Date: 09 March 2023
Our ref: Case: 13622
Your ref: EN010098

Application by Ørsted Hornsea Project Four Limited (“the Applicant”) for an Order granting Development Consent for the proposed Hornsea Project Four Offshore Wind Farm (“Hornsea Project Four”)

The following constitutes Natural England’s formal statutory response to the Secretary of State’s Request For Information dated 9th February 2023. To inform this response Natural England have reviewed G9.2 Applicant’s Response to RFI dated 16th December.

Figure 6: Onshore artificial nesting suitable land parcels mapped in relation to wider compensation consultation search area (Cayton Bay to Newbiggin by the Sea).

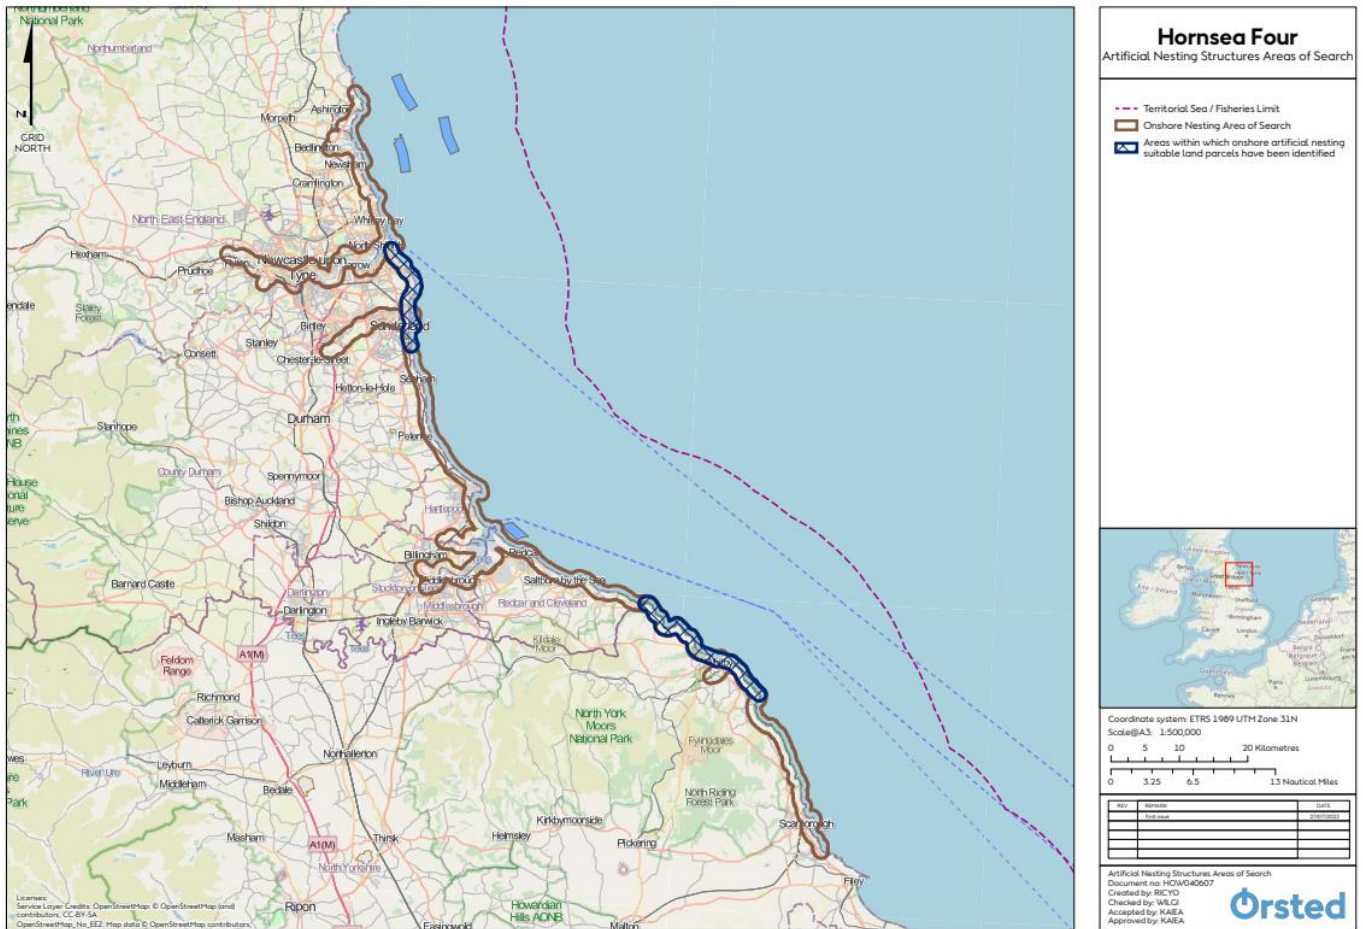
As regards this specific location, the map submitted in response to the December request for further information (G9.3) indicates that a number of adjacent kittiwake colonies along the North Yorkshire coastline are declining, the reasons for which are not understood. This strongly suggests that an ANS in this location may struggle to produce additional adult kittiwake into the biogeographic population from which FFC SPA draws its recruits. Further, the identified search area is within and/or within view of the North York Moors National Park. Depending on the location and design, an ANS could significantly impact on the statutory purposes of the National Park, making a planning permission challenging to secure. This casts further doubt on whether onshore ANS is a suitable intervention in this area of search.
